**Consultation Response from KC,
Highways Development Management**

2024/92081 land adj, 36, Oxford Road, Dewsbury, WF13 4LL

Discharge of details reserved by conditions 3 (Remediation Strategy), 5 (CEMP:Biodiversity), 6 (CEMP), 7 (Arboricultural Method Statement), 8 (highway condition survey), 9 (Drainage strategy), 10 (Temporary drainage), 11 (BEMP) and 15 (oil / petrol inteceptor) of previous permission 2023/92712 for erection of 40 bed care home and 12 independent supported living units (use class C2) with associated works including the formation of car park and service access

Date Responded: 2-9-2024.

6.0 Traffic Management Plan

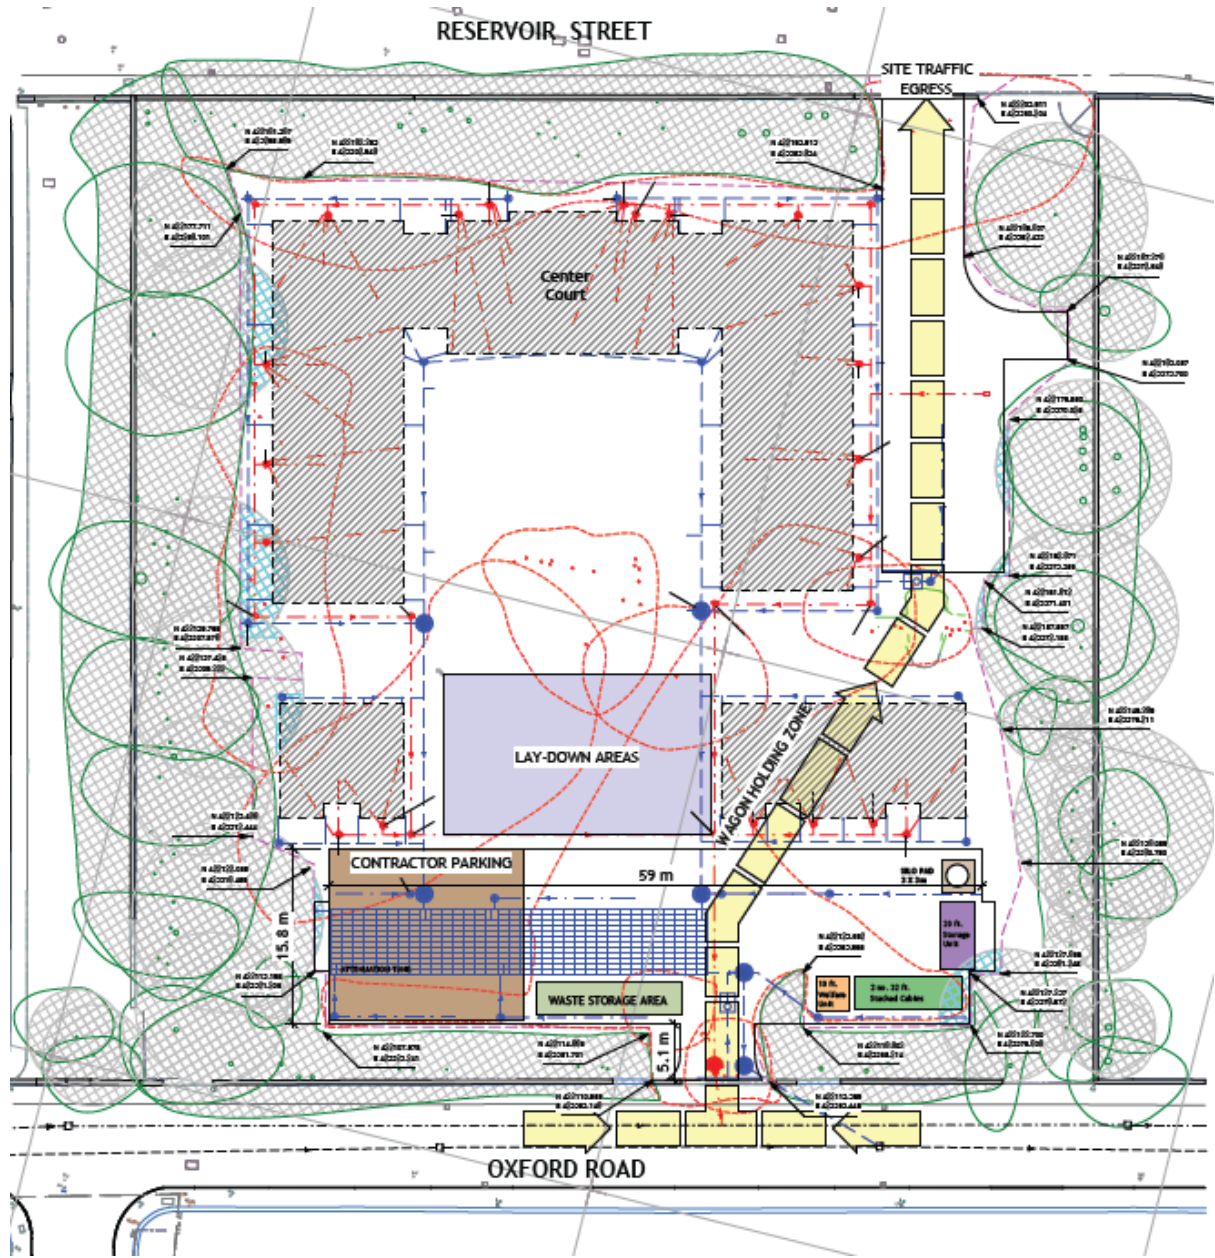
The CMP makes no mention of measures to be taken to minimise the deposit of mud, grit and dirt on public highways by vehicles travelling to and from the site, including the provision of adequate wheel washing facilities within the site or street sweeping.

The CMP should confirm that deliveries to the site will be outside the peak hours for the nearby St John Fishers Academy and Westborough High School.

This condition should **not** therefore be discharge.
